**KIRKLEES METROPOLITAN COUNCIL
INVESTMENT & REGENERATION SERVICE**

Reference No: 2021/62/92290/W

Site Address: 5, Banks Road, Golcar, Huddersfield, HD7 4LX

Description: Erection of two storey side extension and formation of 3 parking spaces to front

Rev	Date	Detail
Drawing Status:		
Client:		
Terryanne Dyson		
Site:		
5 Banks Road Golcar HD7 4LX		
Drawing Title:		
Proposed Plans and Elevations		
Project Number:	Drawing Number:	Revision:
P417	10	A
Date:	Scale:	Drawn:
20-05-21	1:100 @ A3	DGE

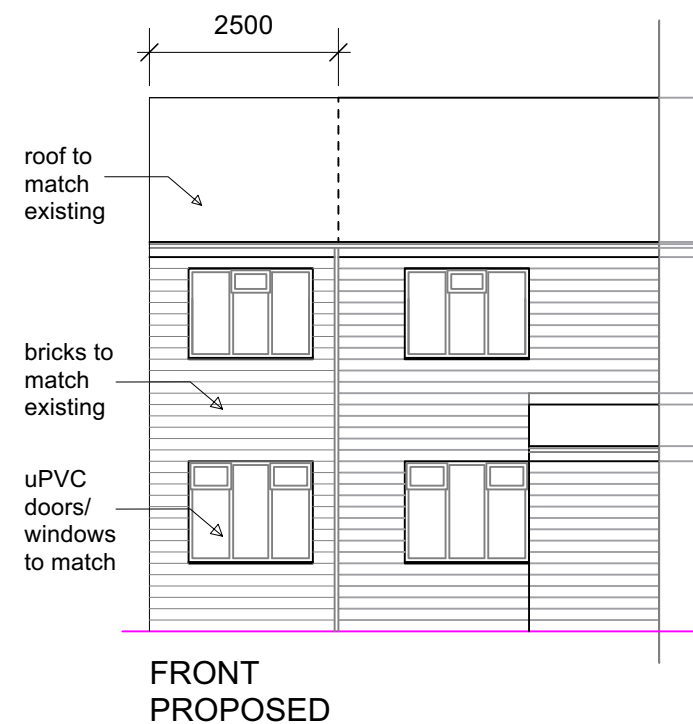
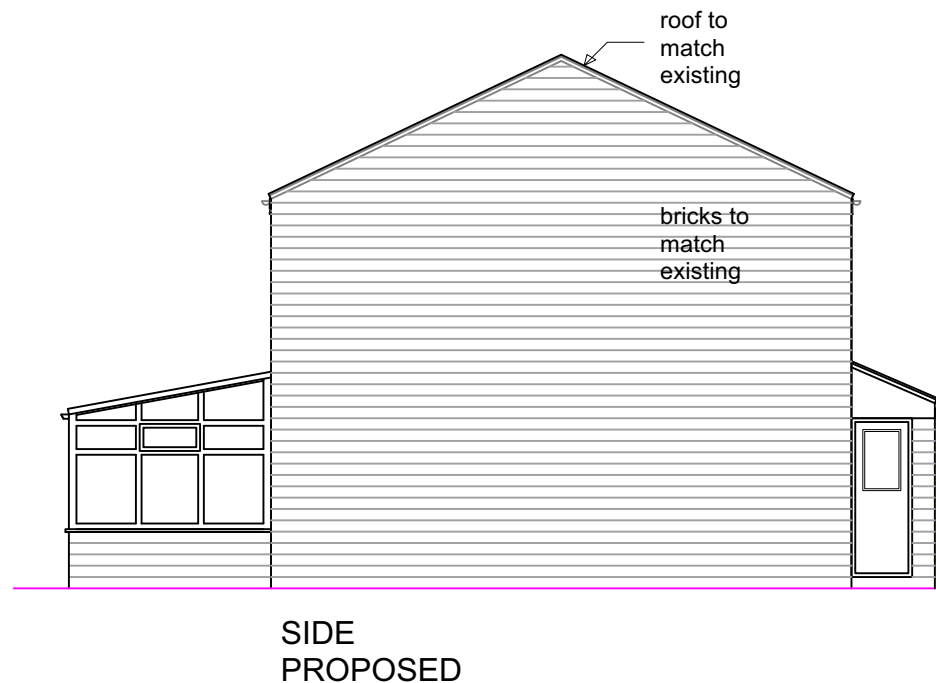
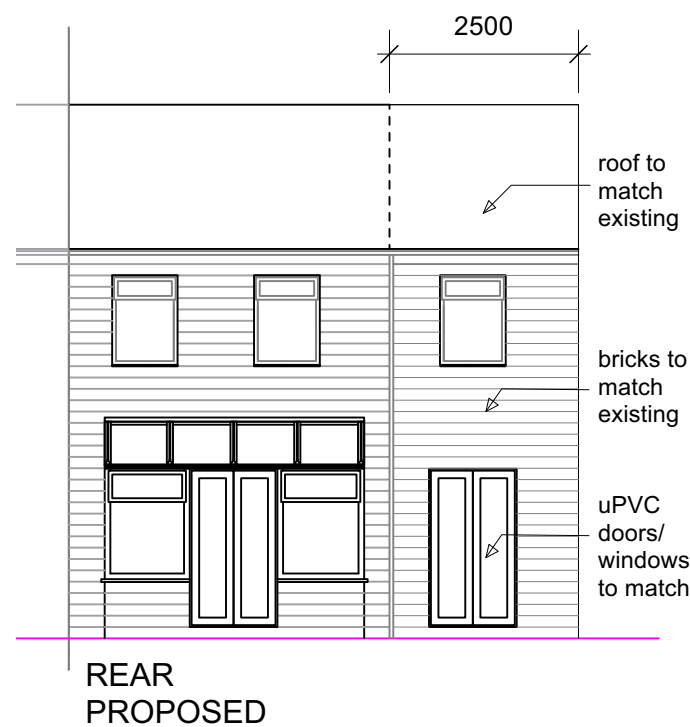
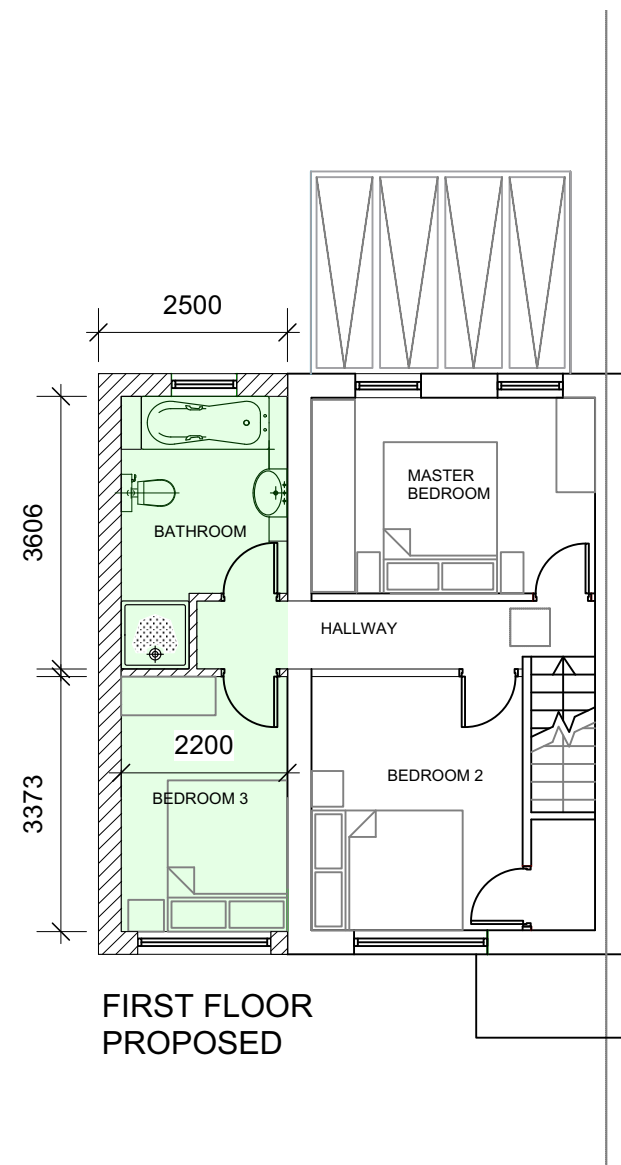
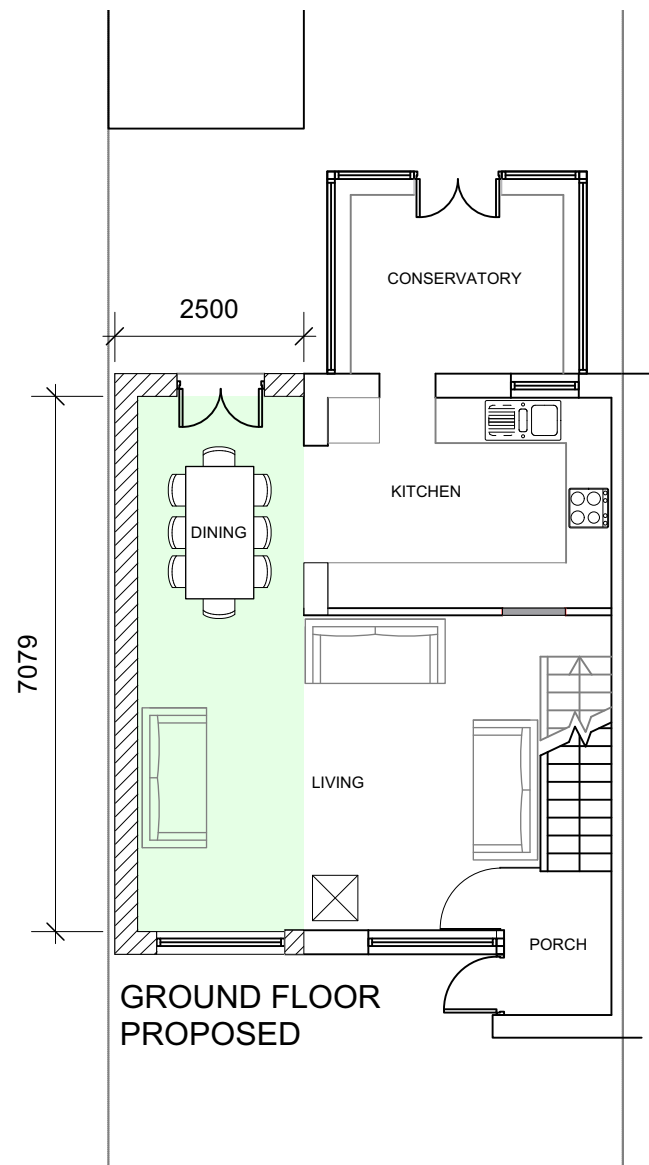
Amended plans were requested by the case officer to ensure that the proposed extension was stepped down from the ridge of the host dwelling and back from the principal elevation to ensure that the extension remained subservient in the interests of visual amenity. Proposed bin storage points were also added.

Drawing Title:
Location and Site Plan

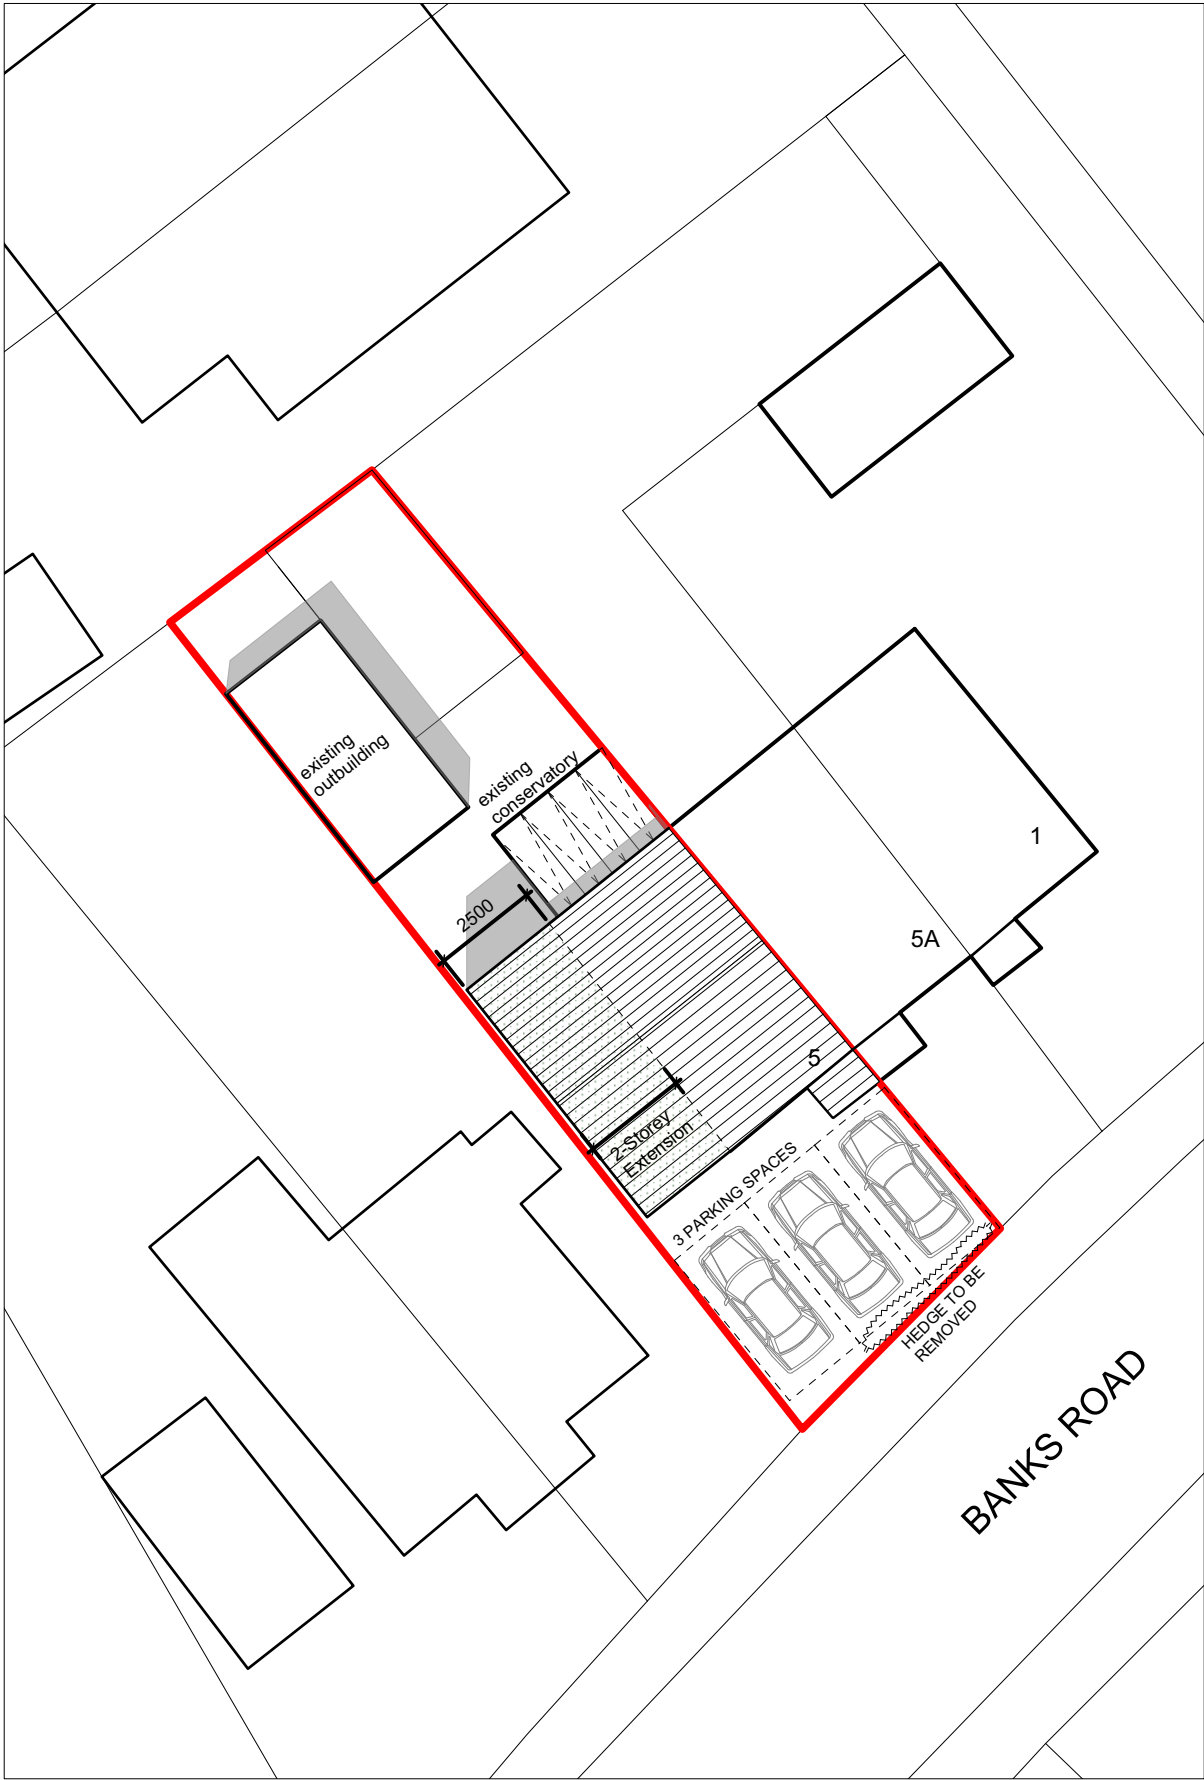
The proposals also seek to replace the existing grassed garden area to the front of the dwelling with 2 additional car parking spaces, the existing hedge will need to be removed to accommodate this change.

As the proposals will see a reduction in car parking spaces available on the driveway and within the detached garage the applicant is proposing to create 2 additional car parking spaces to the front of the dwelling by removing the existing grassed garden area and hedging. As the dwelling is to have 3 bedrooms off-street car parking should be made available for at least 2 vehicles. The proposals will provide 3 off-street parking spaces and therefore it is considered that the scheme would not represent any additional harm in terms of highway safety and as such complies with Local Plan Policies LP21 and LP22, and the guidance contained within the National Planning Policy Framework.

3. The development shall not be brought into use until all areas indicated to be used for parking on the submitted plans have been laid out with a hardened and drained surface in accordance with the Communities and Local Government; and Environment Agencies 'Guidance on the permeable surfacing of front gardens (parking areas)' published 13th May 2009 (ISBN 9781409804864) as amended or any successor guidance. Notwithstanding the provisions of the Town and Country Planning (General Permitted Development) Order 2015 as amended (or any Order revoking or re-enacting that Order) these areas shall be so retained, free of obstructions and available for the use specified on the submitted plans.

Rev	Date	Detail
Drawing Status:		
Client:		
Terryanne Dyson		
Site:		
5 Banks Road Golcar HD7 4LX		
Drawing Title:		
Proposed Plans and Elevations		
Project Number:	Drawing Number:	Revision:
P417	10	B
Date:	Scale:	Drawn:
20-05-21	1:100 @ A3	DGE

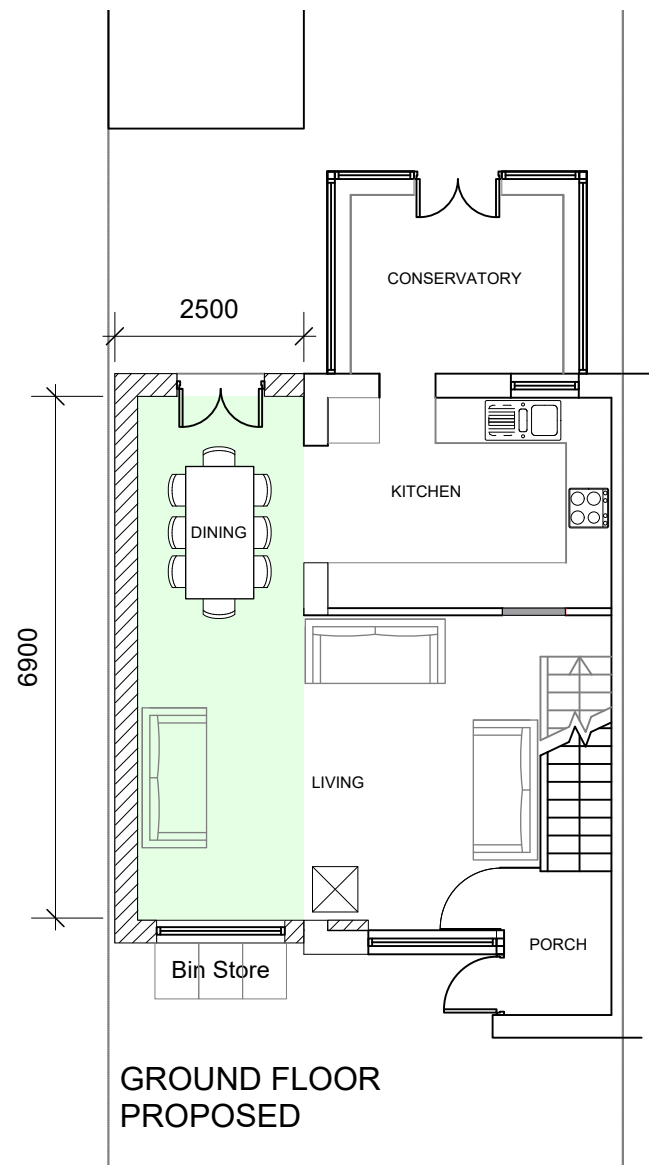
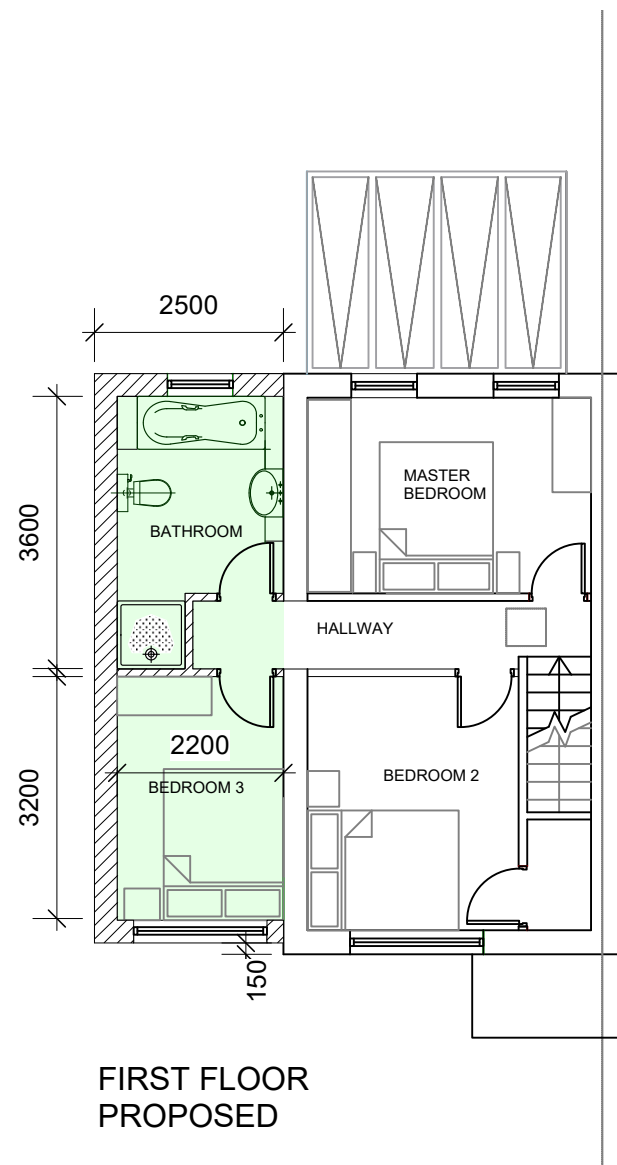
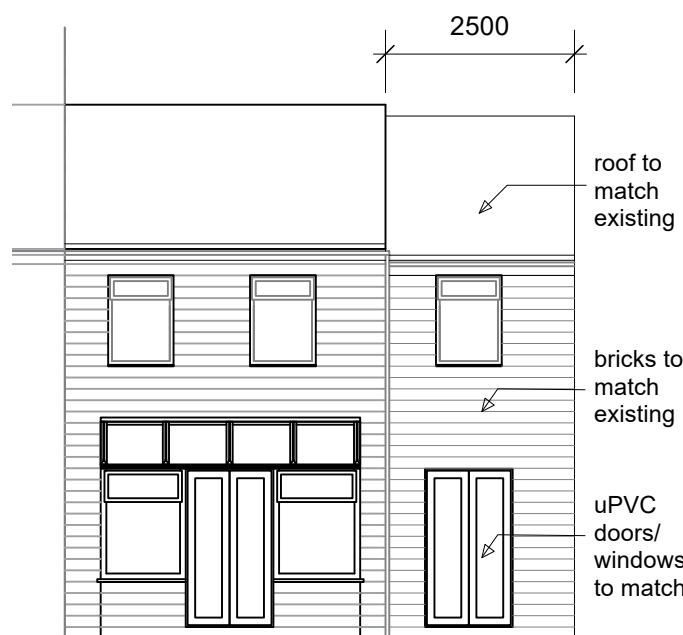
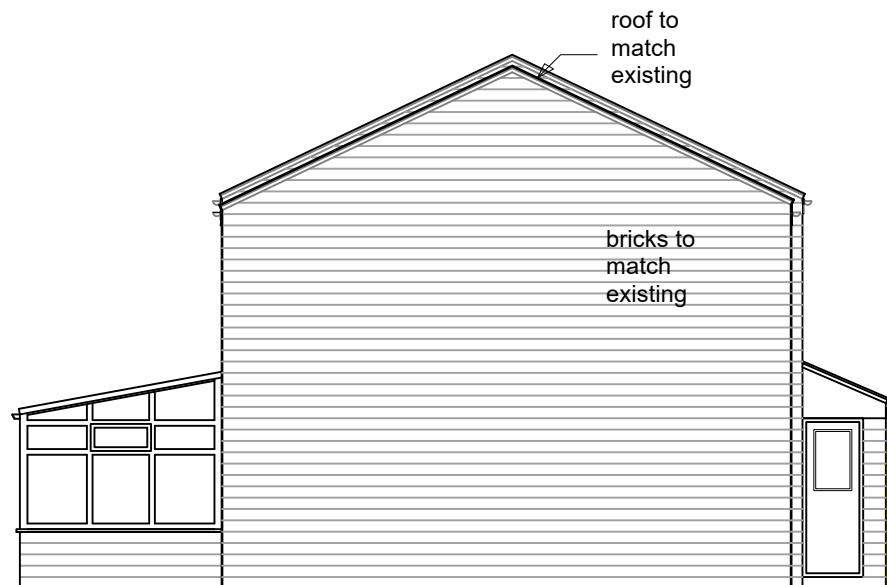
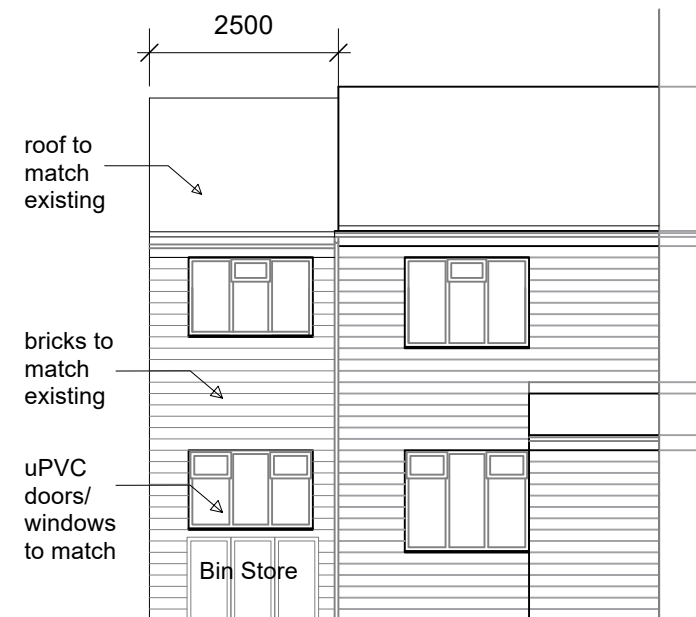
Whilst the proposed two storey side extension would be openly visible from the public domain and is somewhat large in scale and size, it would be stepped back from the principal elevation of the host dwelling, and down from the ridge. This would ensure that the proposals appear subservient to the host dwelling and would not appear to dominate the street scene. Moreover, the host dwelling benefits from a curtilage which is considered to be of a sufficient size to support the proposed extensions without amounting to overdevelopment. There would also be a reasonable amenity space retained for the occupiers of the dwelling.

This neighbouring property is located to the south of the application site. As no windows are proposed within the southern elevation of the proposed side extension there are no concerns in respect to overlooking or loss of privacy. It is noted that during the morning there would be some additional overshadowing towards no. 3 from the proposed side extension, however, this would fall across the existing driveway and would not be for a prolonged period of the day. In addition to this, whilst the proposed extension is somewhat large in scale and size, it will be viewed against the existing two storey dwelling and be stepped down from the ridge of the host dwelling and stepped back from the principal elevation. It is also important to note that no.

4. The development shall not be occupied until the first-floor bathroom window on the rear elevation of the extension hereby approved have been fitted with obscure glazing, minimum grade 4. Notwithstanding the provisions of section 55(2)(a)(ii) of the Town and Country Planning Act 1990 and the Town and Country Planning (General Permitted Development) Order 2015 (or any Order revoking or re-enacting that Order with or without modification) the window shall thereafter be so retained obscure glazed.
